From: Joyce Christie
Sent: 04 August 2022 19:26
To: James Kirkham
Subject: 22/01528/LB and 22/01527/F 14-15 High St Banbury

Application No.: 22/01528/LB
Applicant's Name: Langham Holdings Ltd
Proposal: Conversion of upper floors to apartments. New access in front facade
Location: 14 & 15 High Street, Banbury, Oxfordshire, OX16 5EE

WG1103-008 B

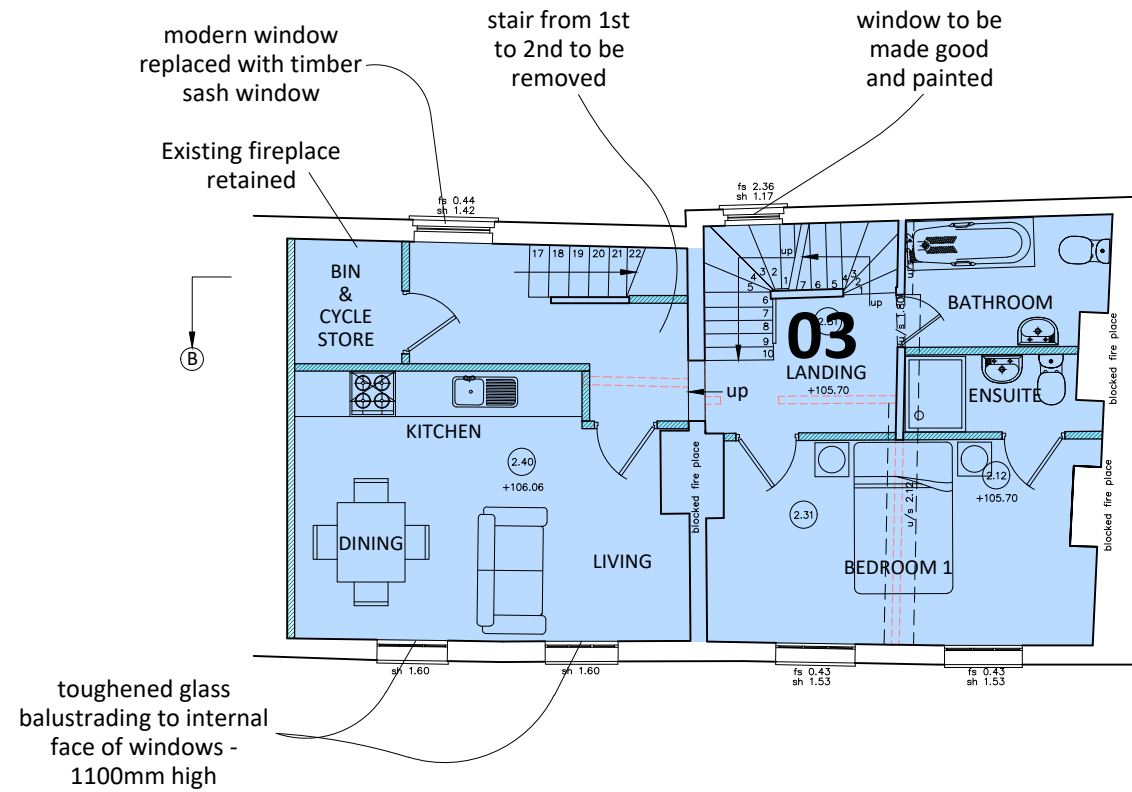
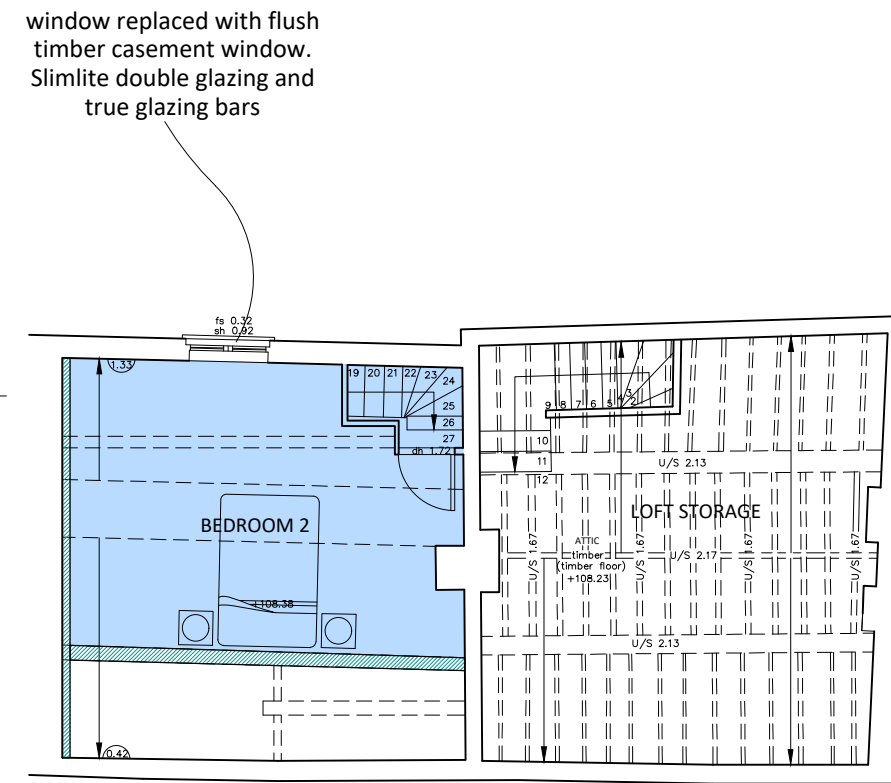
- There are concerns that the new openings at first and second floor between the two buildings (see below photos) do not take account of the cranked chimney breasts in these locations and may be too close to the top of the stair on the second floor.. This may result in the need to remove the chimney breasts which wouldn't be desirable. We need an elevation to show how the door linking the two properties would fit with the cranked chimney breast shown, looking from No 15 and looking from No 14 at both first and second floor.

- The Conservation Officer has stated that the stair in No 15 from 1st to 2nd is of greater significance than the stair to be blocked in No 14, although the balustrade is of interest in no 14. In order to get a corridor between the two properties we may have to sacrifice the stair from 1st to 2nd floor in No 14 which has substantially been rebuilt, but retain the balustrade and newel to the upper flight, and the historic stair above to the attic. Making this change to No14 could improve the 2nd floor plan and avoid the a partition dividing the rear window which is not considered to be appropriate.

- Kitchen window of plot 1 relocated to existing opening – Agreed.
- Access between 14 and 15 for plot 2 has been moved to accommodate the cranked chimney breast. This has been achieved by removing the staircase Agreed, this is necessary to give access to these rooms.
- Plot 3 kitchen/living room redesigned (due to removal of staircase) where the existing rear window and the existing fireplace is retained Agreed.
- Toughened glass balustrading is proposed to the window serving plot 3 kitchen/living – details can be conditioned.
- Shopfront altered to be similar to Joyce's sketch. I would suggest the detailed design of this shopfront is conditioned details can be conditioned.

**WG1103-010 A**

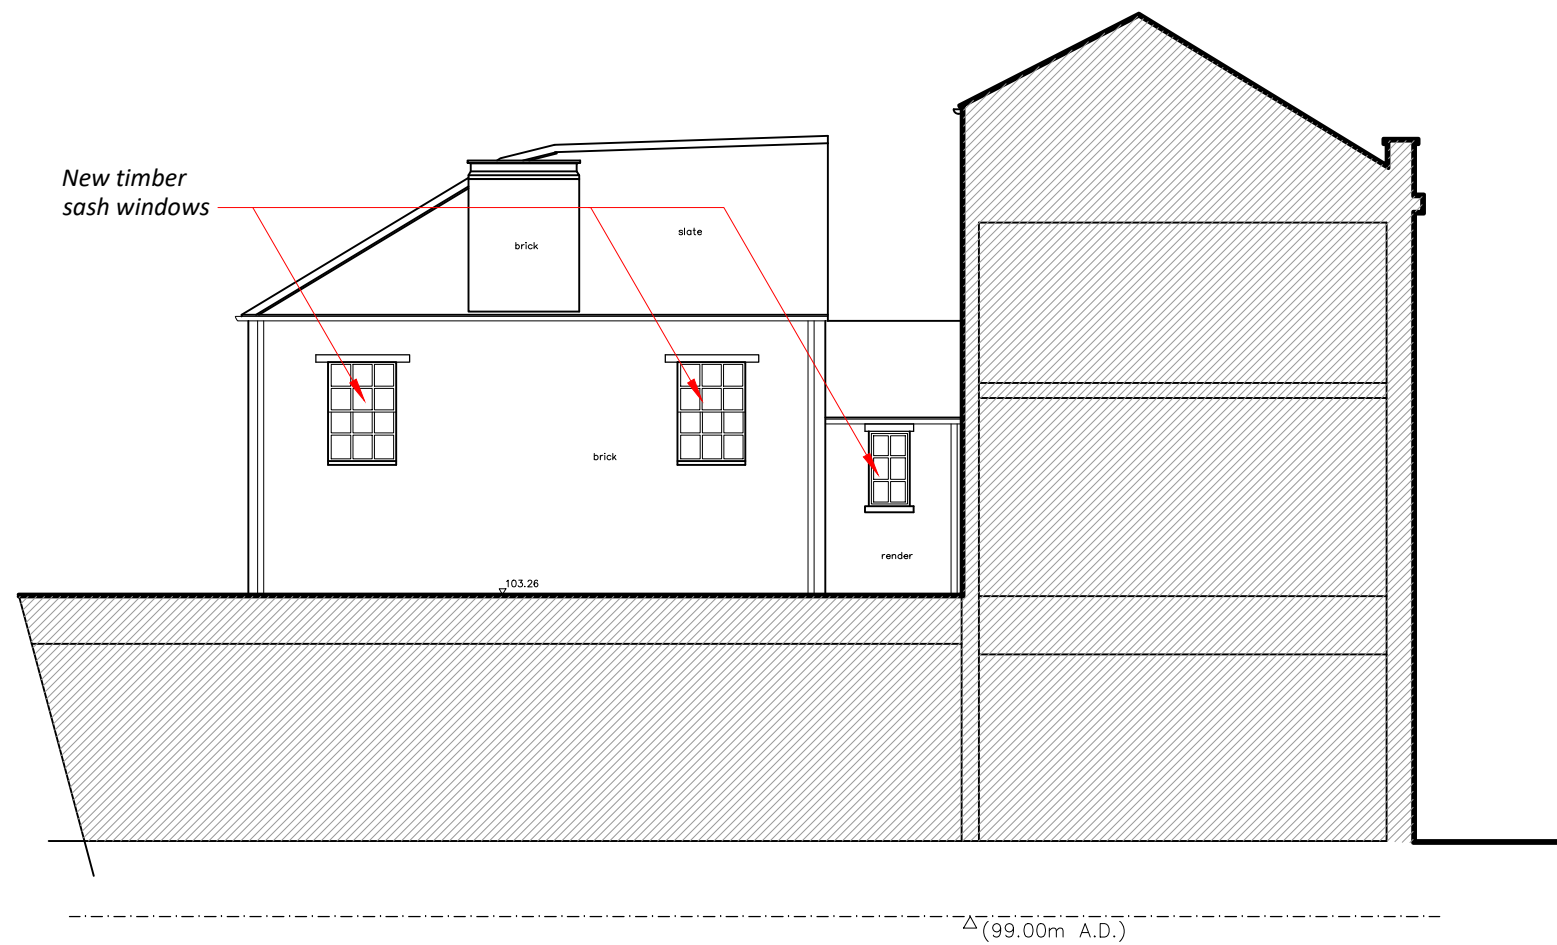
- No 15: New openings are proposed in the wall below. the LH window appears to cut into the chimney breast and brick feature on the exterior wall? Any new openings should be sensitive to what remains of historic interest. Could the window to the kitchen not move further towards the gable, or use the existing opening, this avoiding the chimney breast?
